KITTITAS COUNTY FIRE MARSHAL'S OFFICE

April 6, 2015

Re: Penta (BL-15-00002)

After conducting a review of the recent changes to the above named project, I have the following comments:

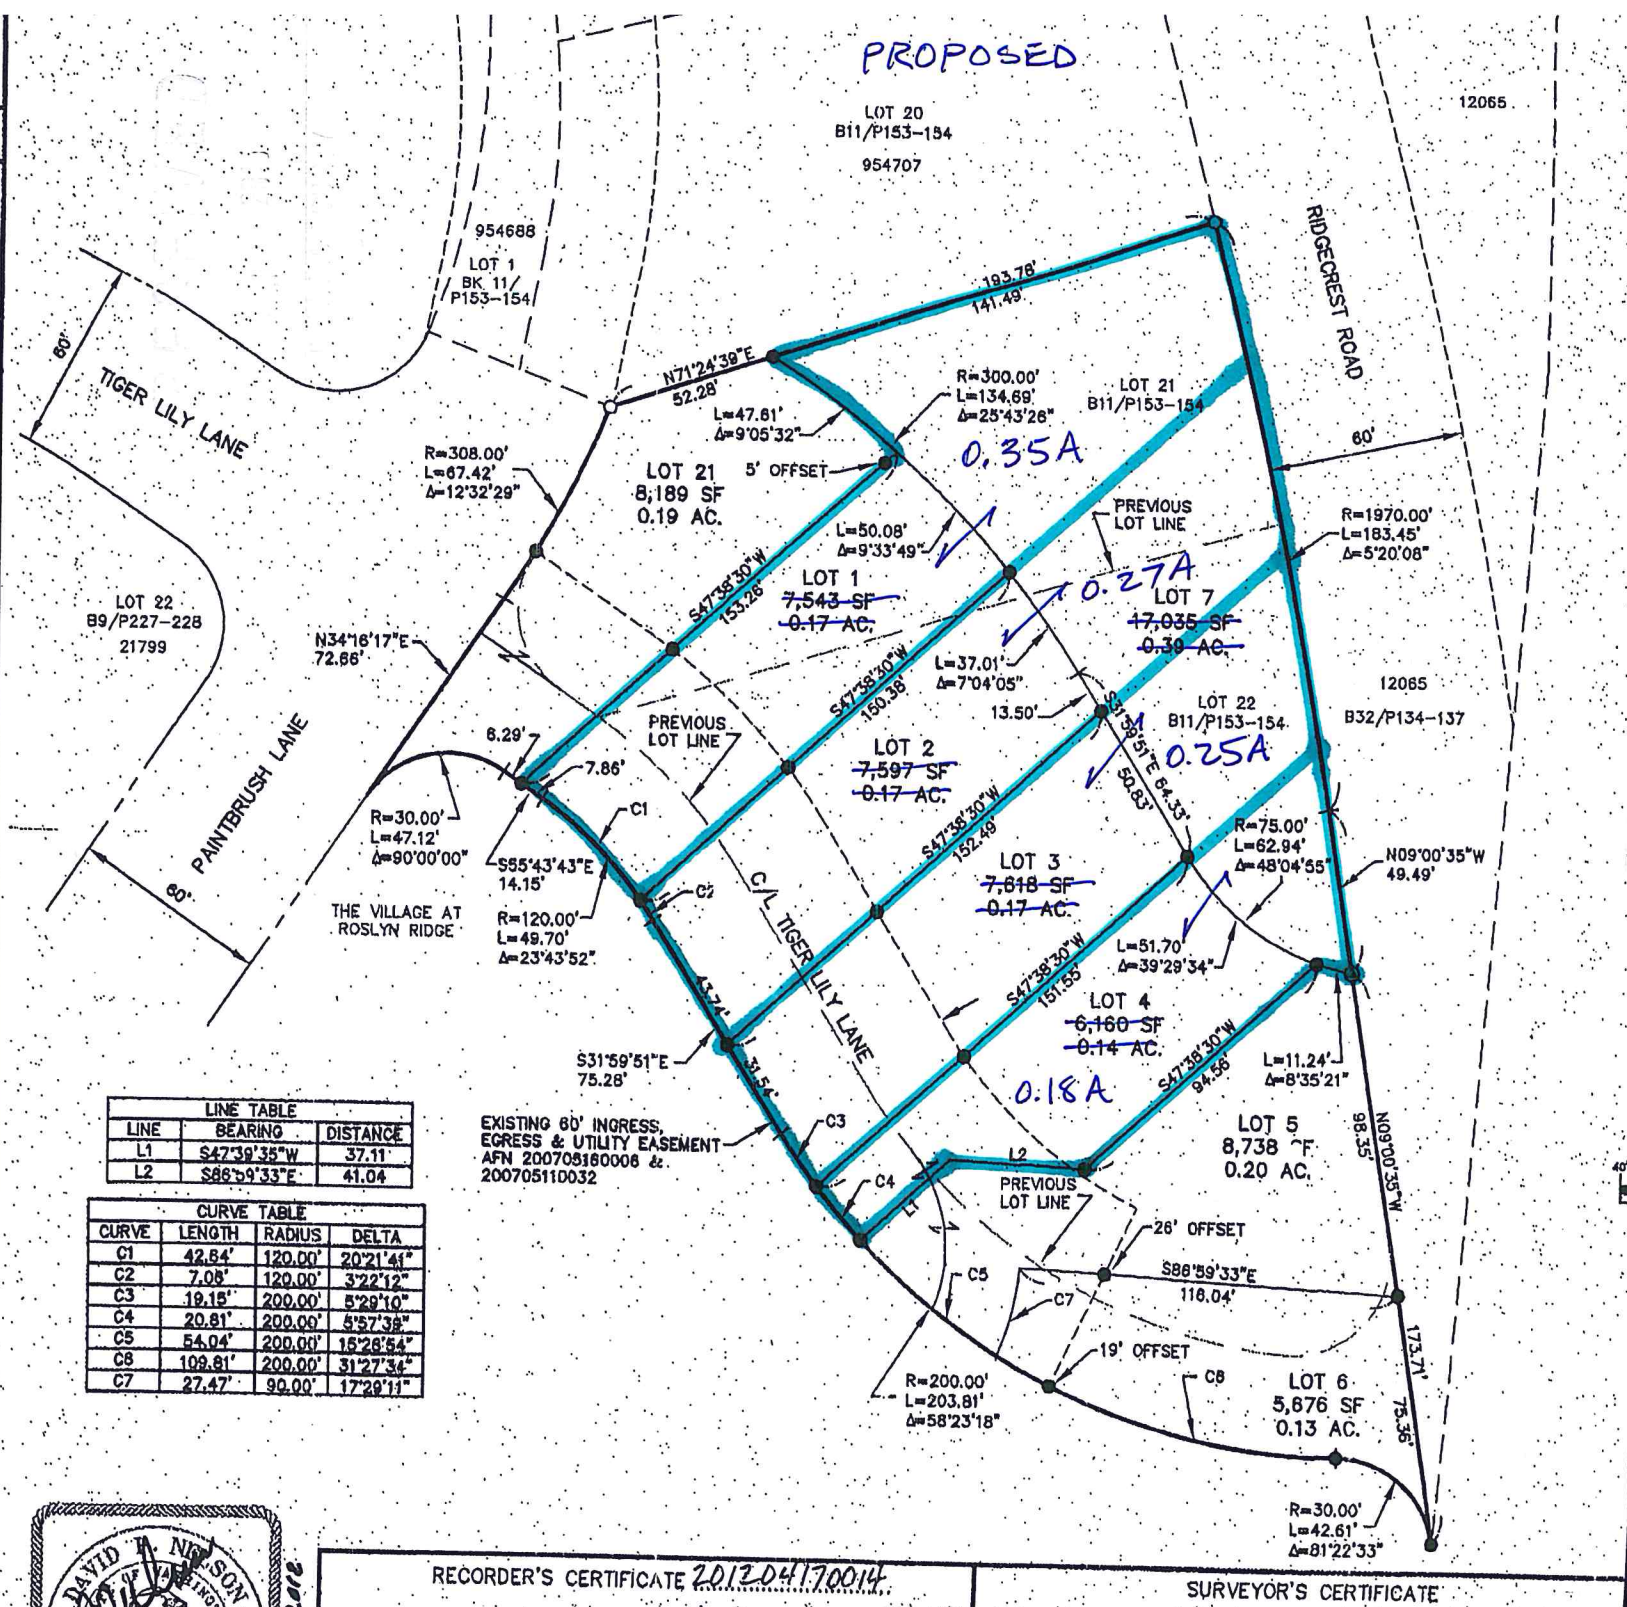
- Ensure that boundary line adjustments do not infringe upon existing structures, to include propane tanks, etc.
- Ensure adequate access for fire apparatus. Any driveways or access points created based off the new lot configurations shall comply with Kittitas County Code 20.02.030.
- All future development must comply with the International Fire Code.
